DRB CASE ACTION LOG - BLUE SHEET

Project #: 1010265 Application #: 15DRB-70038
 Project Name: MANKATO PLACE
 Agent: SIOW-TEK Phone #:

15DRB-70037 VACATION OF PUBLIC RIGHT-OF-WAY

15DRB-70038 MINOR - PRELIMINARY/ FINAL PLAT APPROVAL

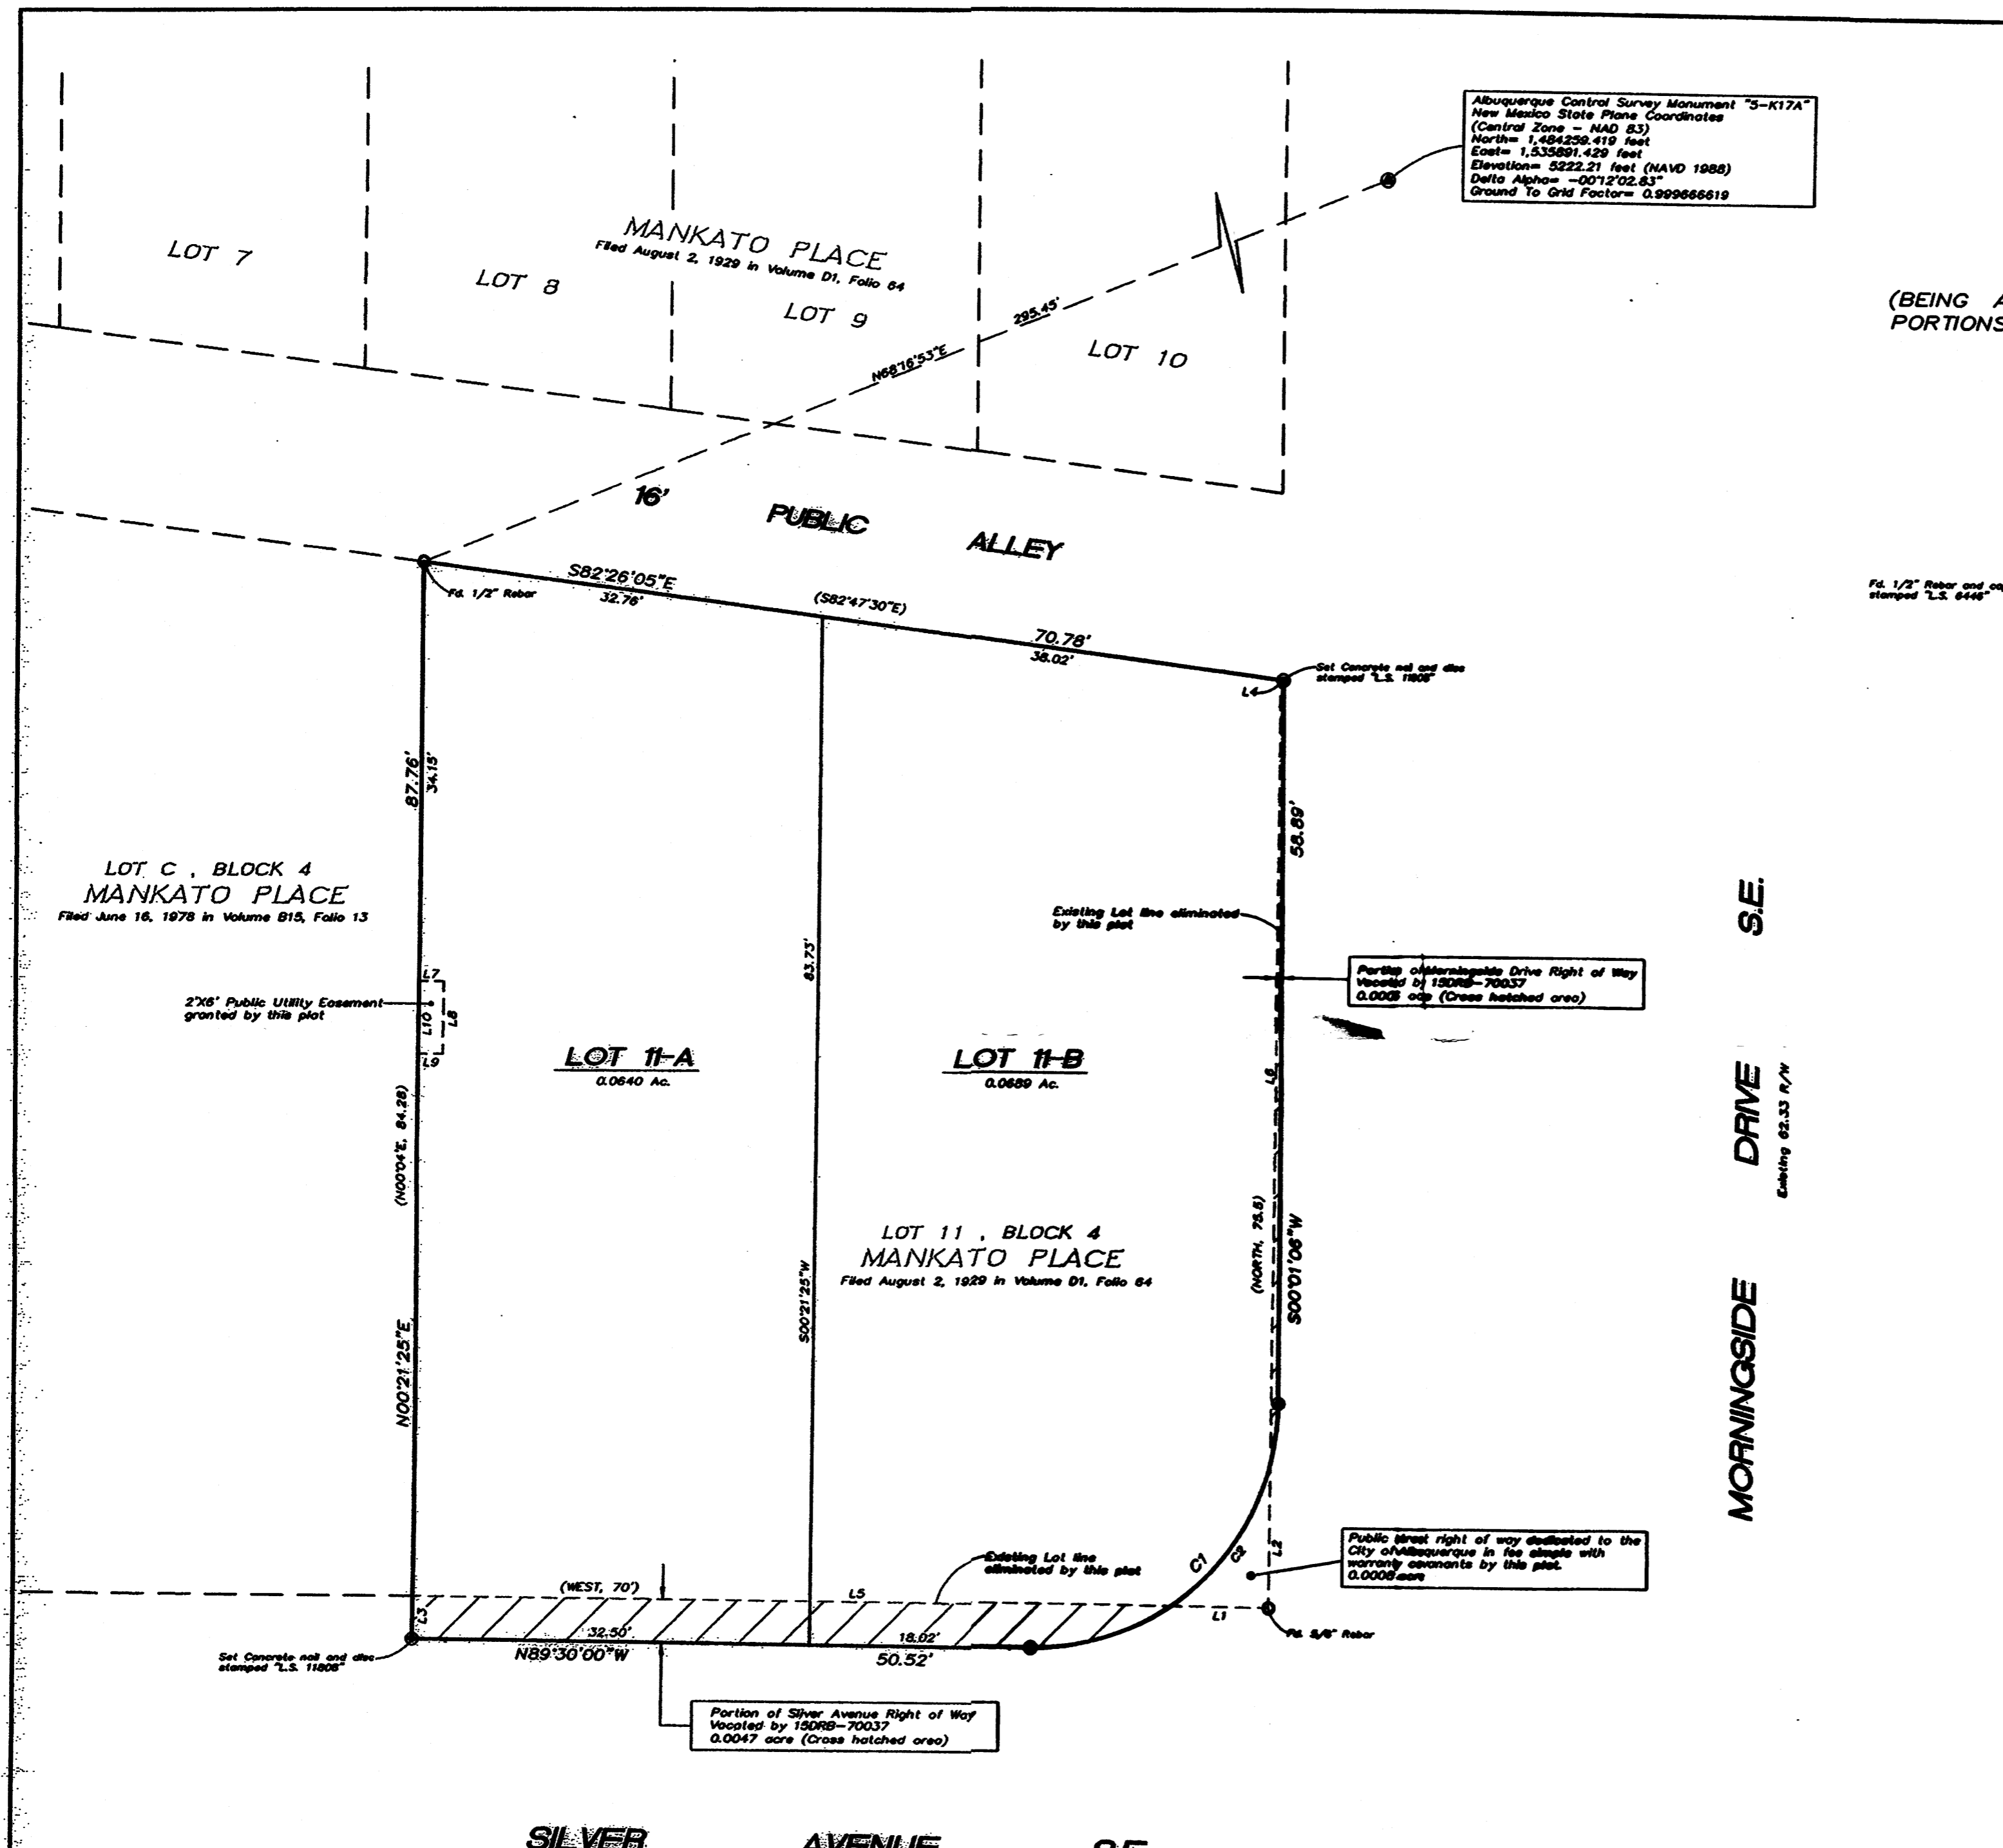
TRANSPORTATION: verify 10' back of curb

VACATION EXHIBIT

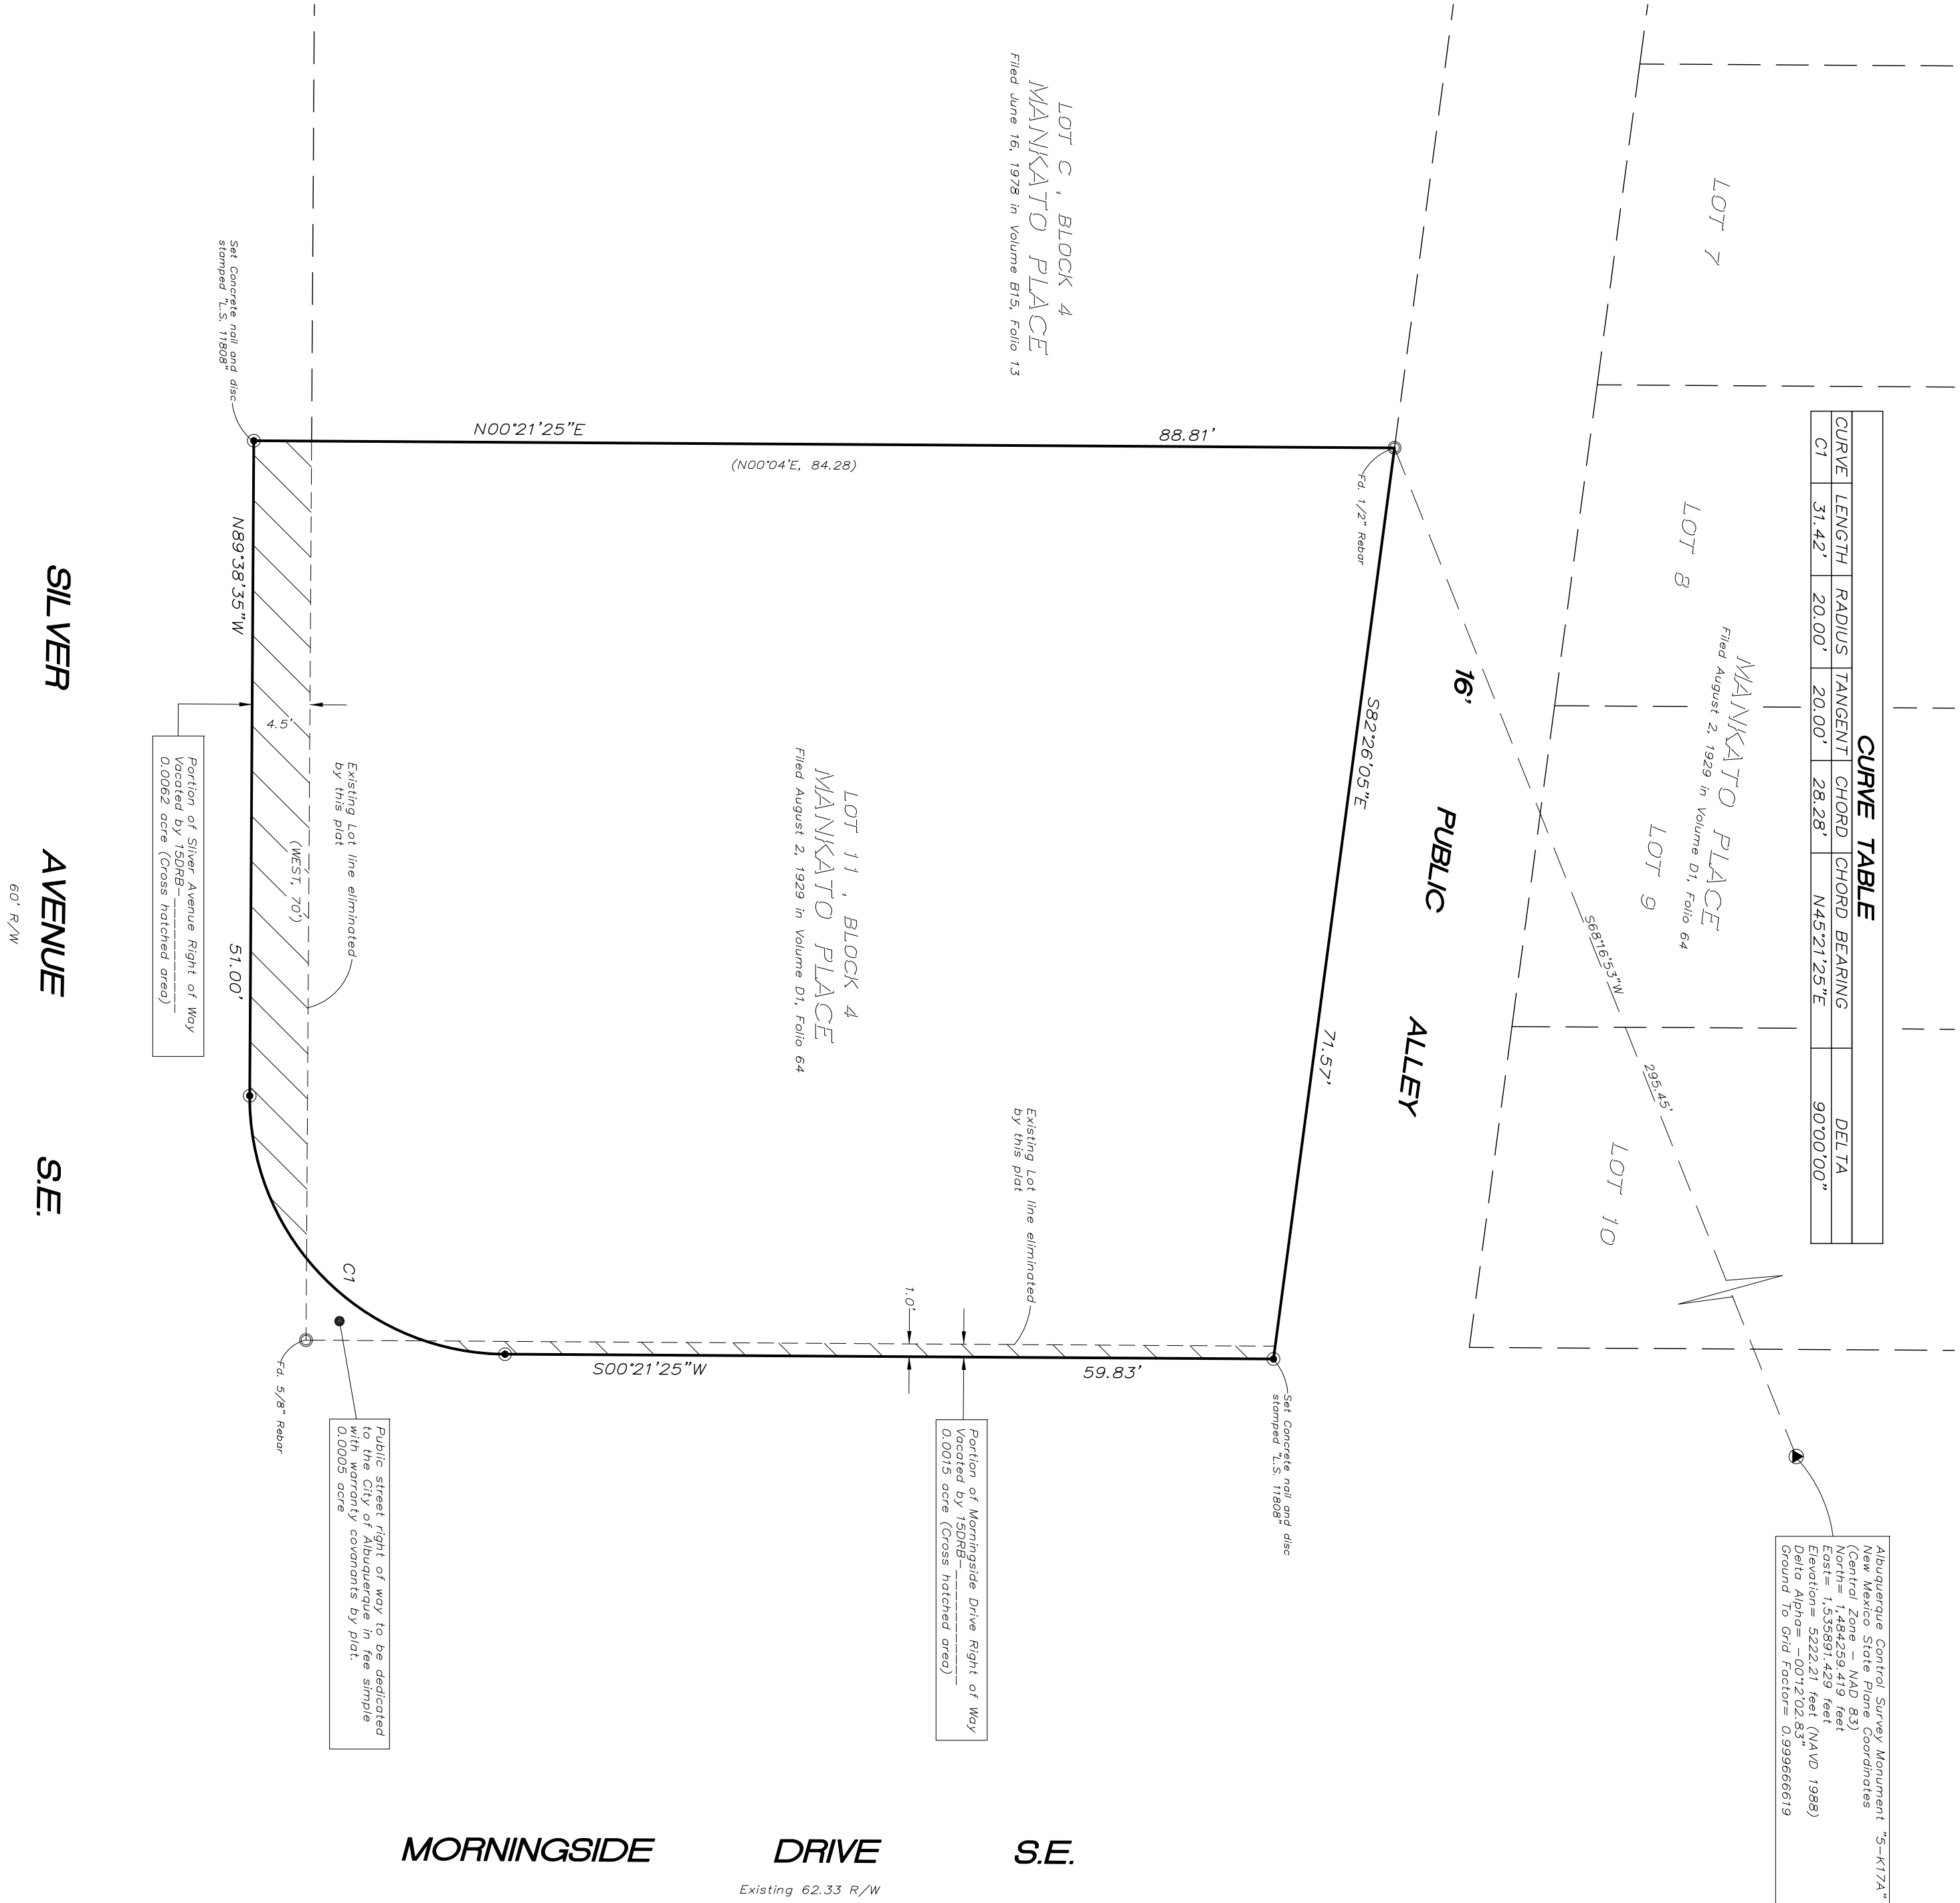
Vacation of Public right of way requires an advertised public hearing; if approved, the vacated right of way must be acquired from the City Real Property Division and replatted into the adjacent lot via a Subdivision Plat prepared by a licensed surveyor within 1 year.
